From: Amanda Scholes on behalf of Planning.Responses
Sent: 19 March 2020 08:31
To: Planning Scanning
Subject: FW: Planning Consultation on: Y/19/20/RES

The further information submitted within Dwgs D2831-FAB-00-XX-DR-L-505-505 PLO1 & D2831-FAB-00-XX-DR-L-401 PLO1 has provided detailed information regarding the POS specification relating to SuDS and onsite play provision.

Application ref: Y/19/20/RES

Description: Approval of reserved matters following outline consent Y/80/16/OUT for 4.5ha of residential development comprising of 3.4ha of land for the erection of 100 No. dwellings (up to 30 (30%) affordable housing) **together with 1.1ha of land set aside for public open space & strategic landscaping & 2.2ha of public open space & green corridors** with vehicular access from Ford Lane & pedestrian/cycle access only from North End Road. This application may affect the setting of listed buildings, affects the character & appearance of the Church Lane, Yapton Conservation Area & affects a Public Right of Way.

Sections location plan scale 1:50 @ A2

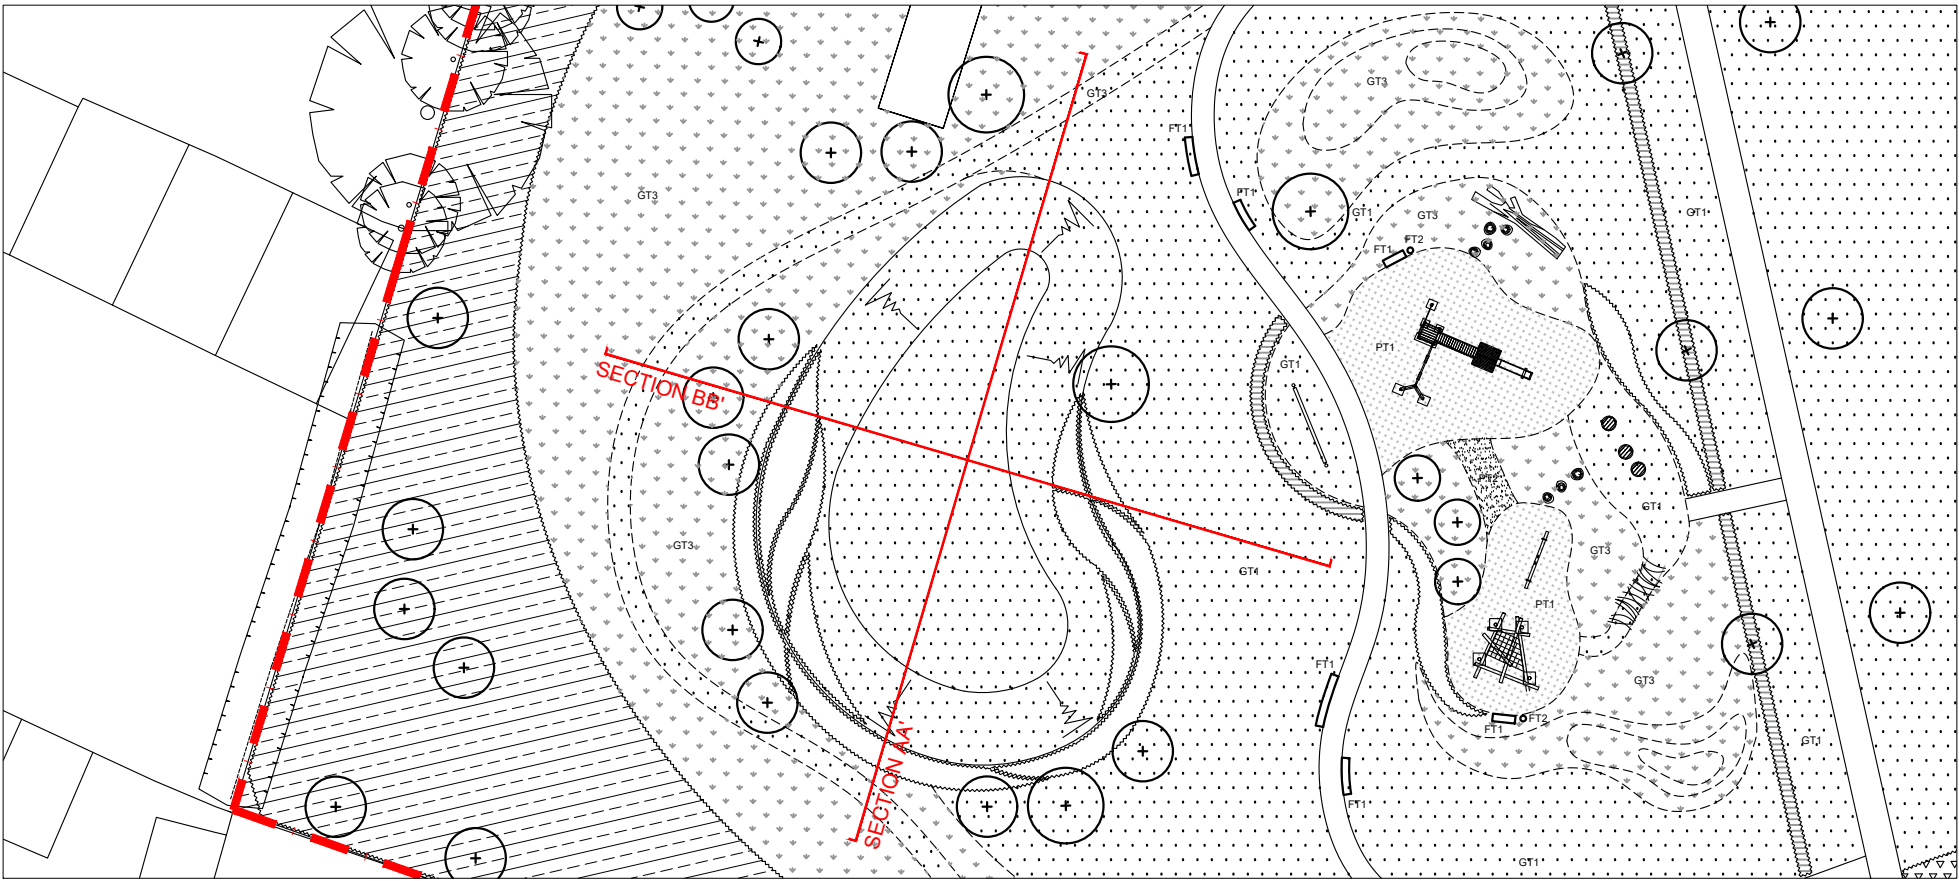
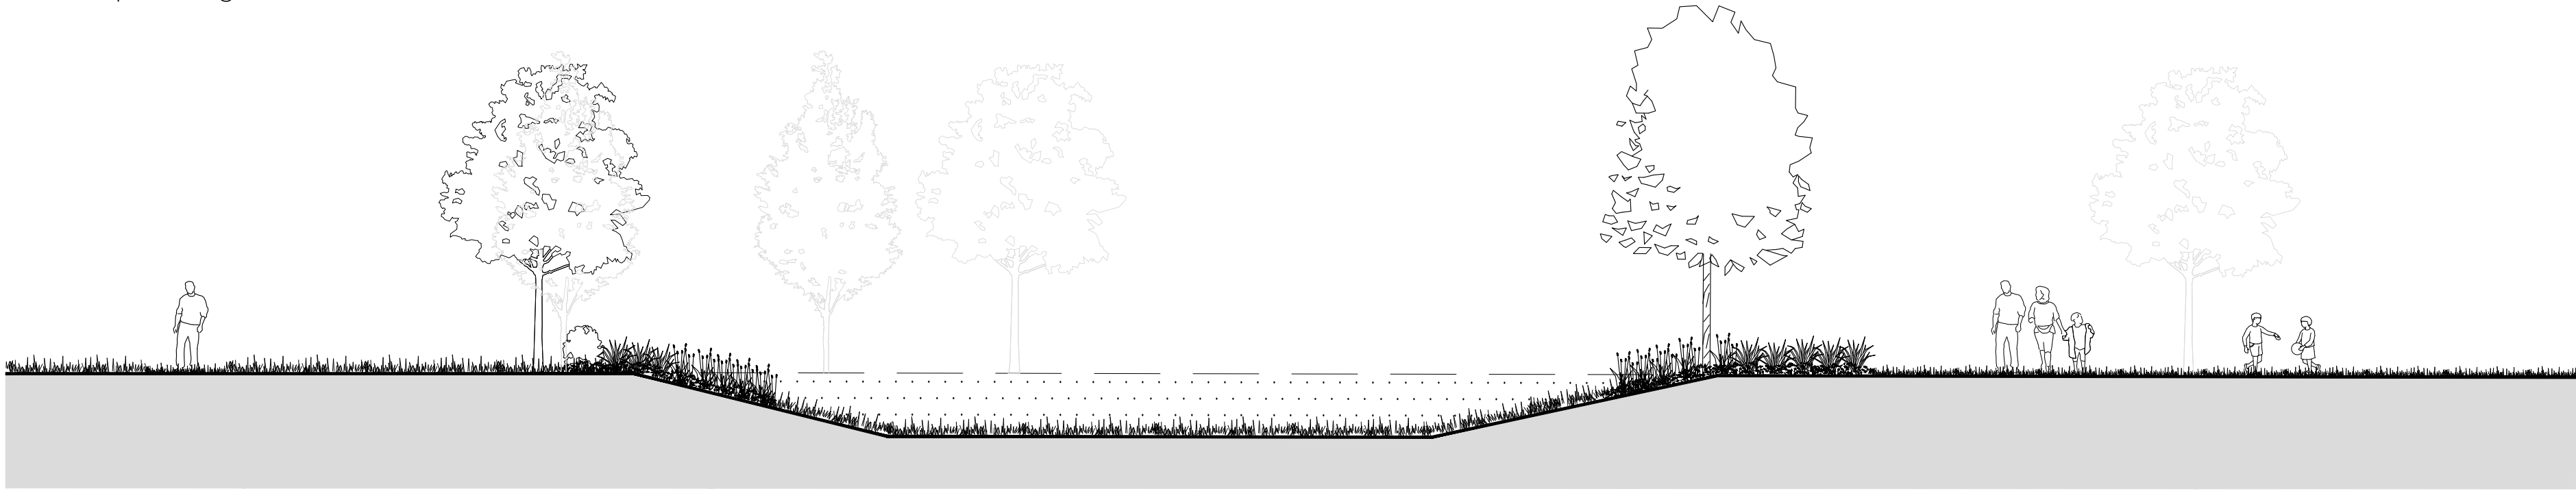
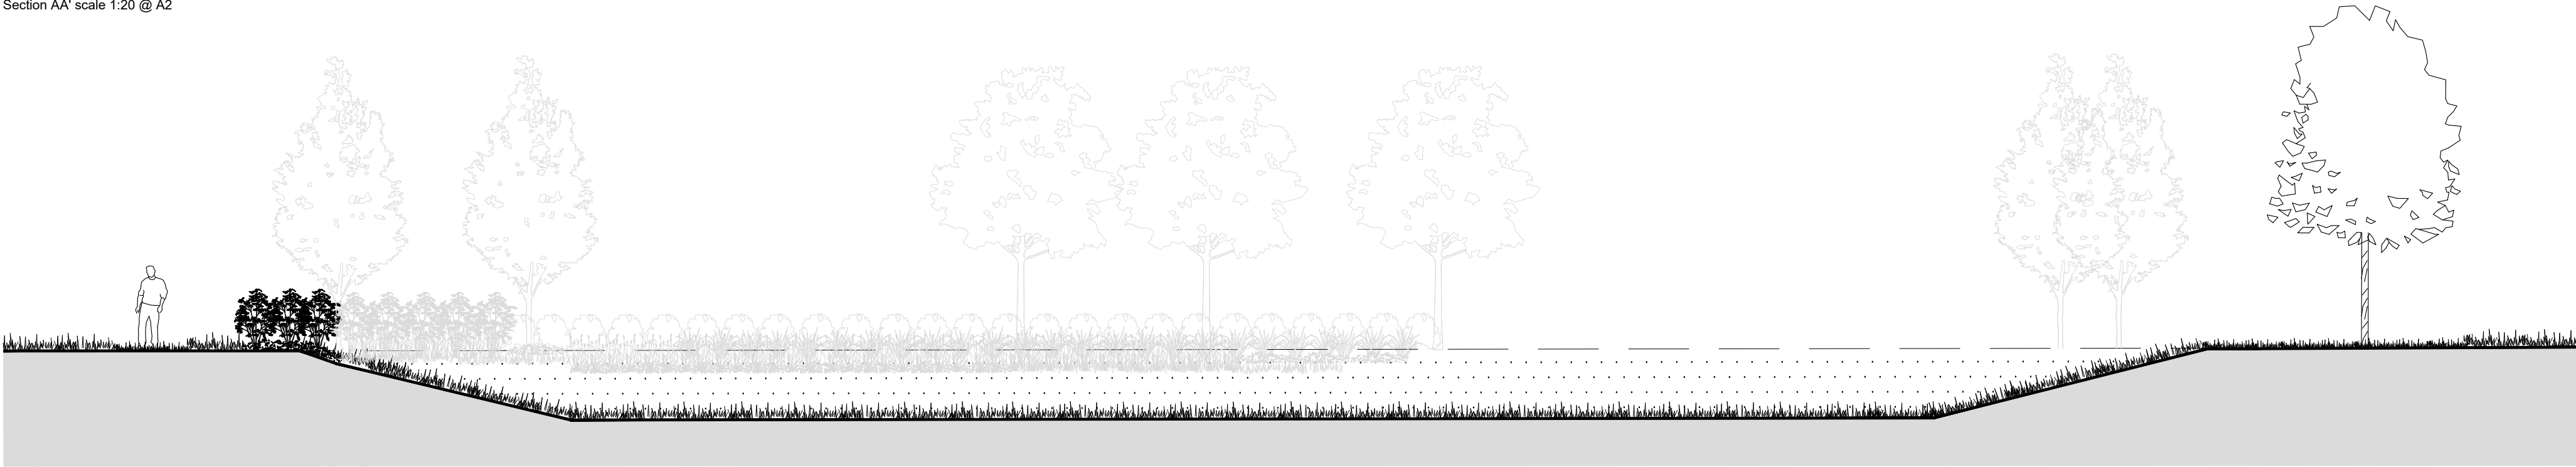
We note the requirement for the large SuDS infiltration basin shown within the POS and the inclusion of marginal planting to integrate this as a positive design feature within the scheme. We would recommend clarification of cross sections and anticipated water holding periods along with any boundary treatment to the SuDS because of the location in relation to dwellings and play. We would advise that ROSPA or similar body are consulted re the proximity of these two features.

Play Area (LAP 2) - Scale 1:100@A1

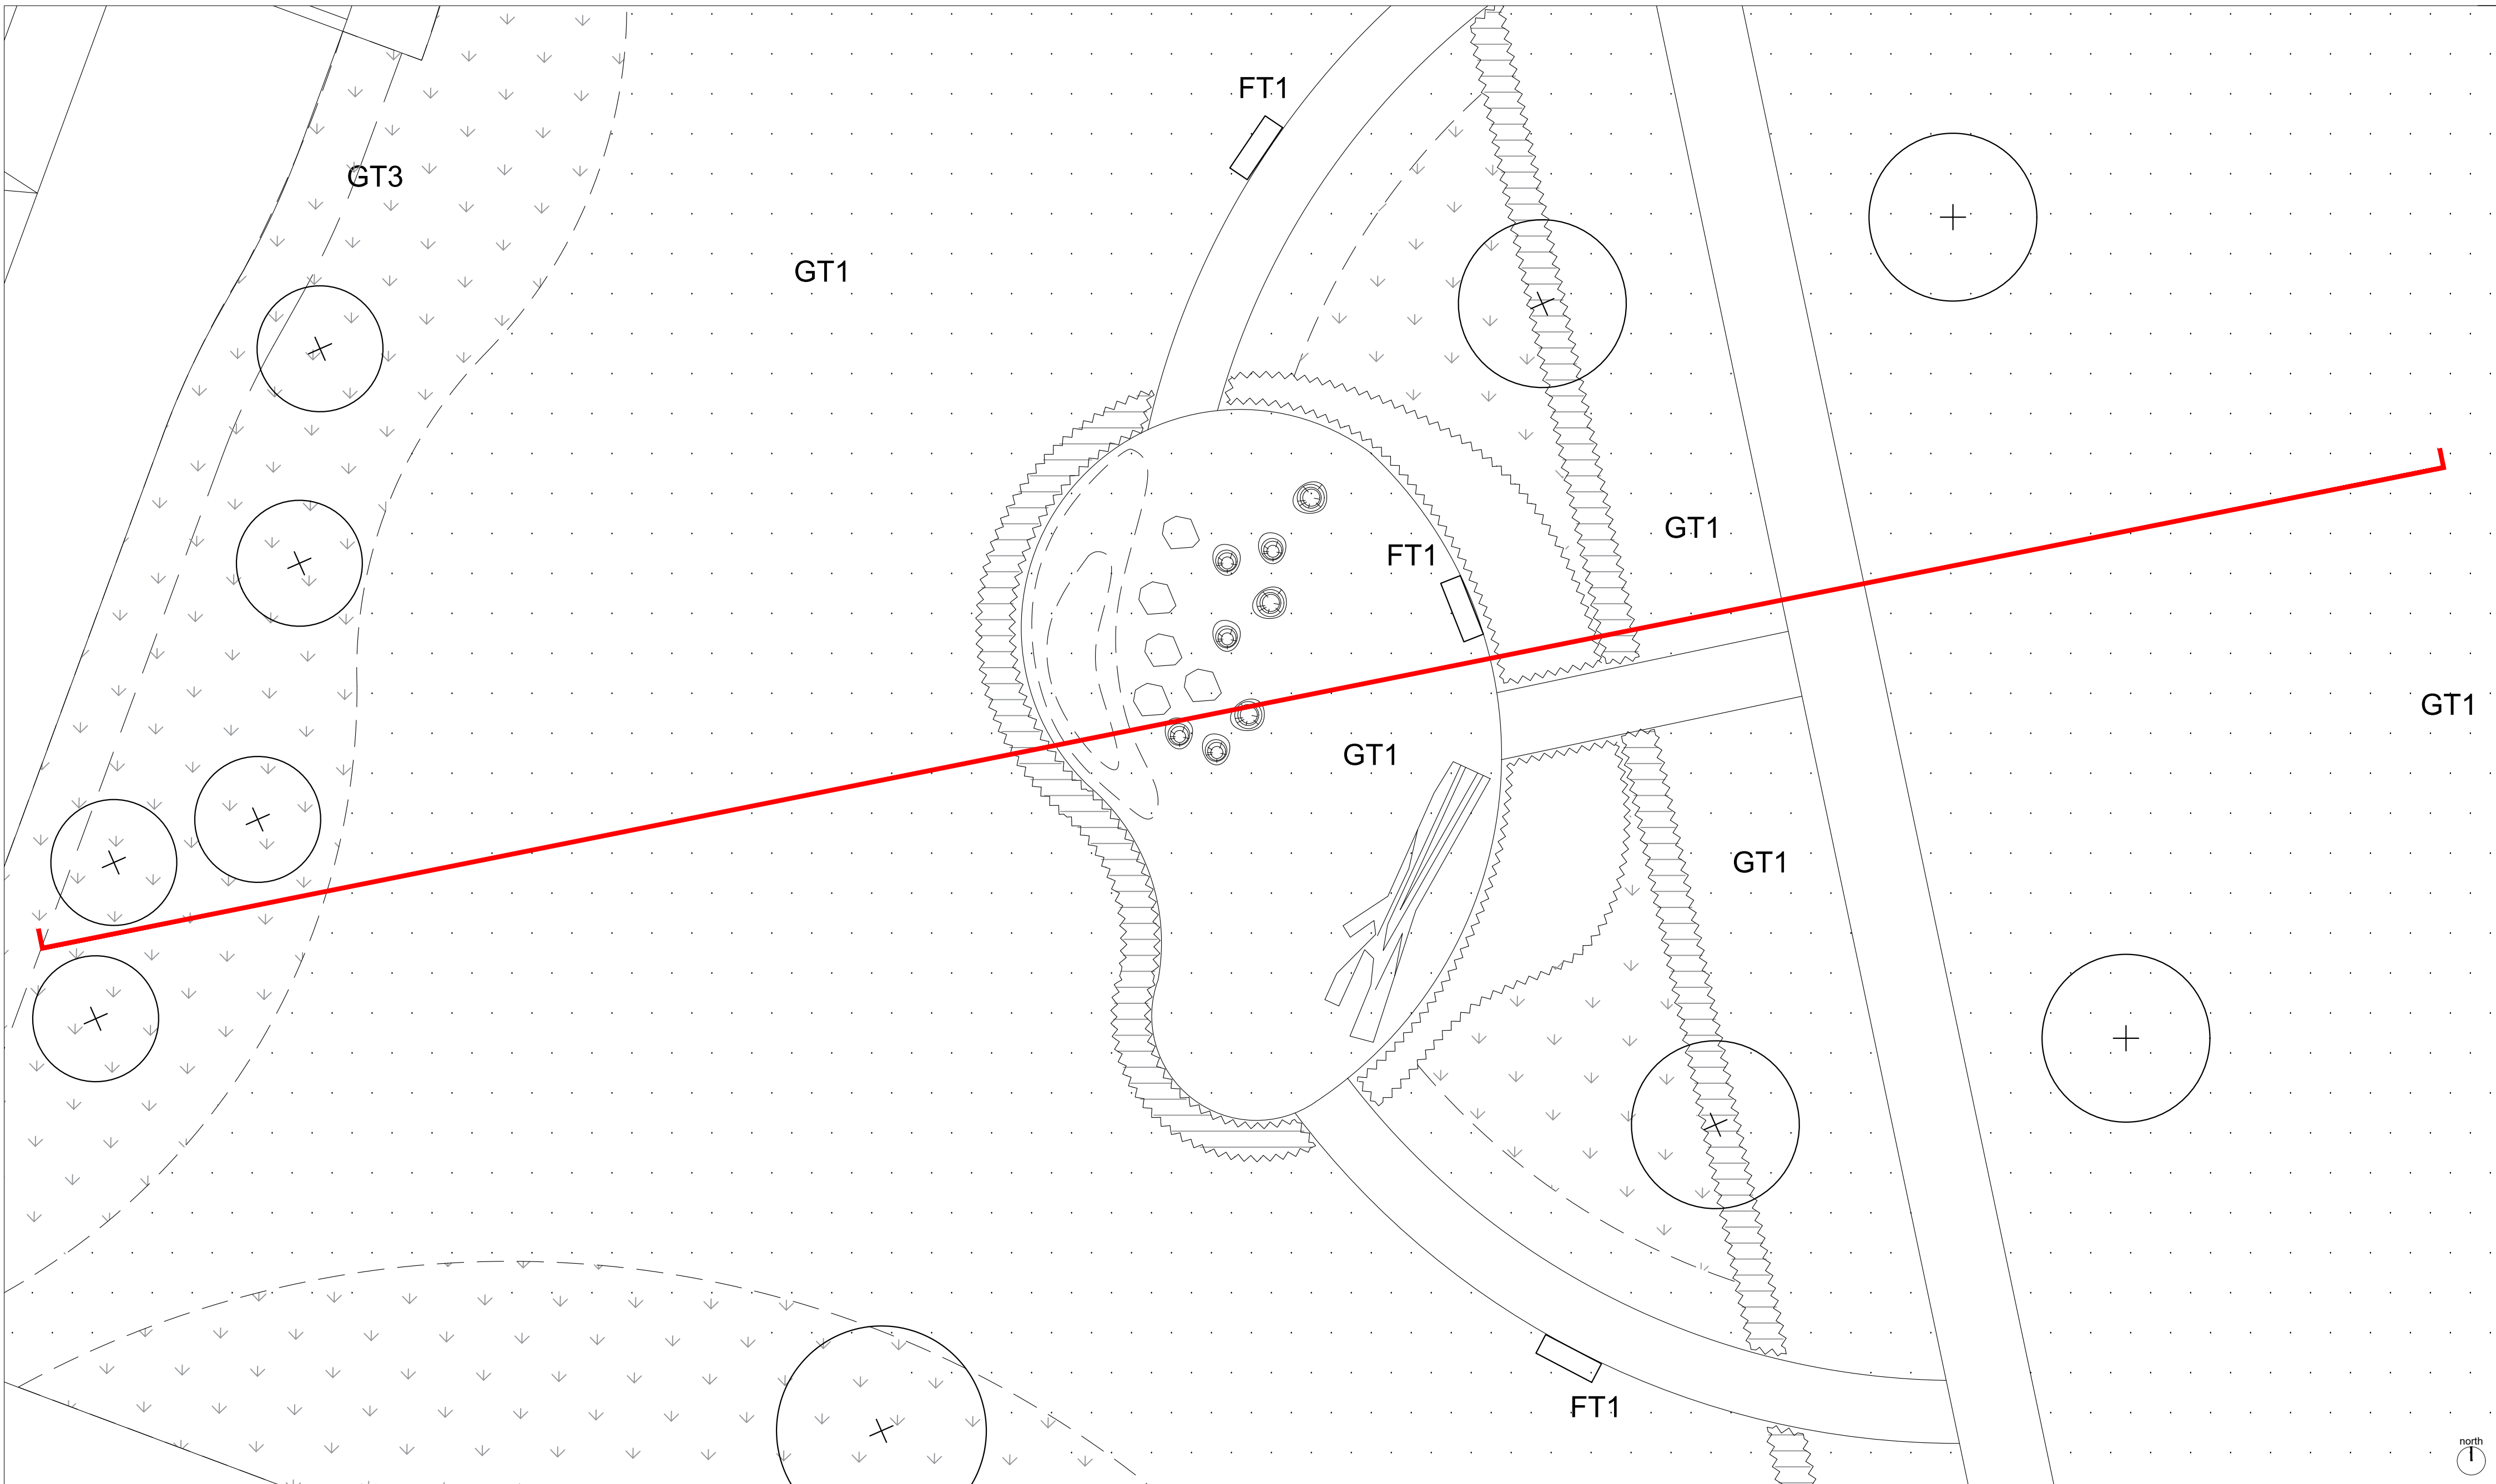
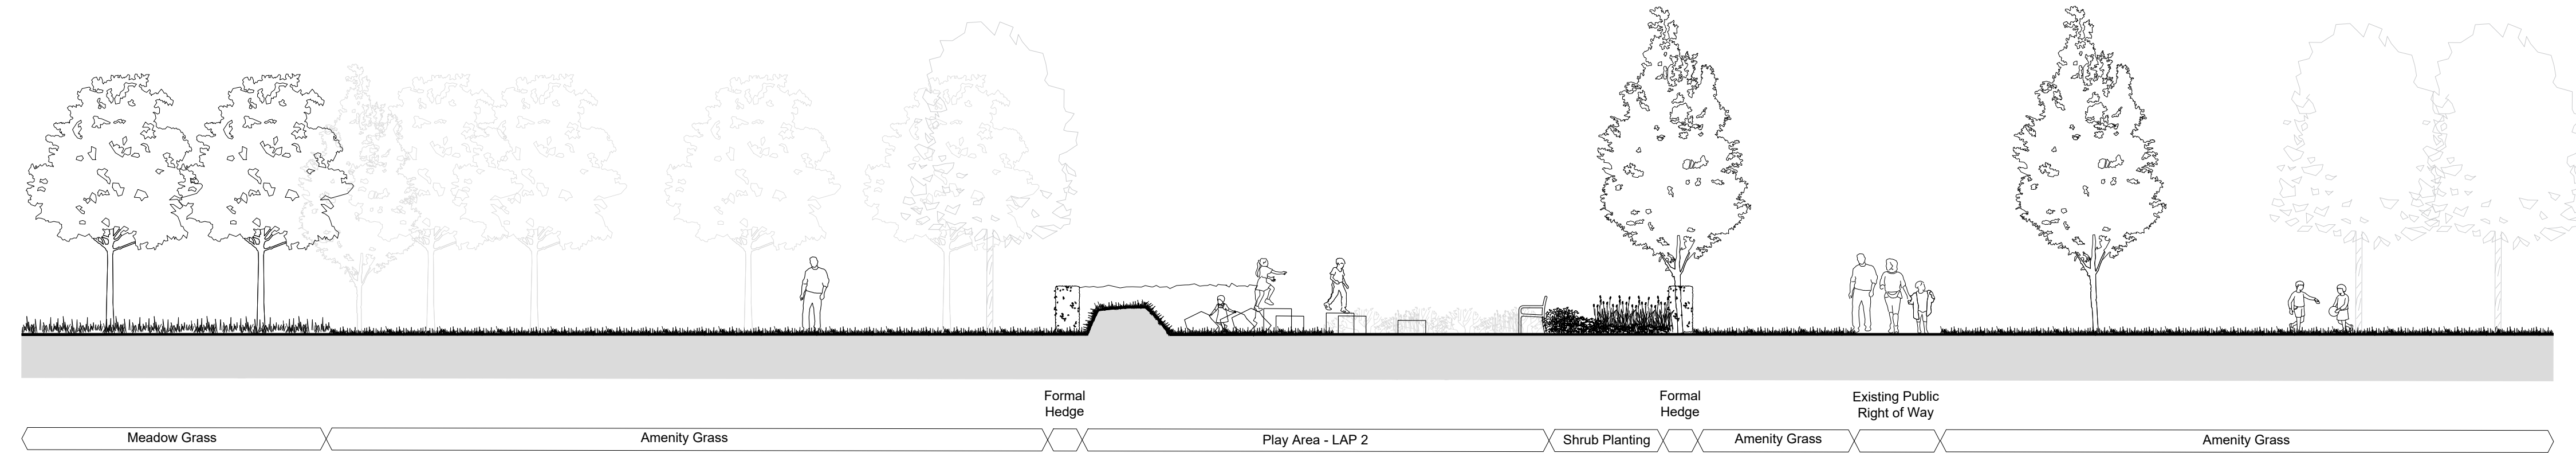
The drawings are detailed and propose a super scheme regarding the play offer to be provided in the form of LAP and LEAP. The choice of play experience to be offered is refreshing to see, has considered the setting and material choice and will provide a very good play offer all round both in the formal LEAP provision and also with an imaginative LAP offer.

The drawings show multiple LAP and 1no LEAP, however there doesn't appear to be any detailed plans which show the proposals for these and the play provision offered. We would need to see the equipment choice, surfacing, fencing and connectivity to the pathway network for the formal play and the design thought for the more informal natural based play space - LAPs
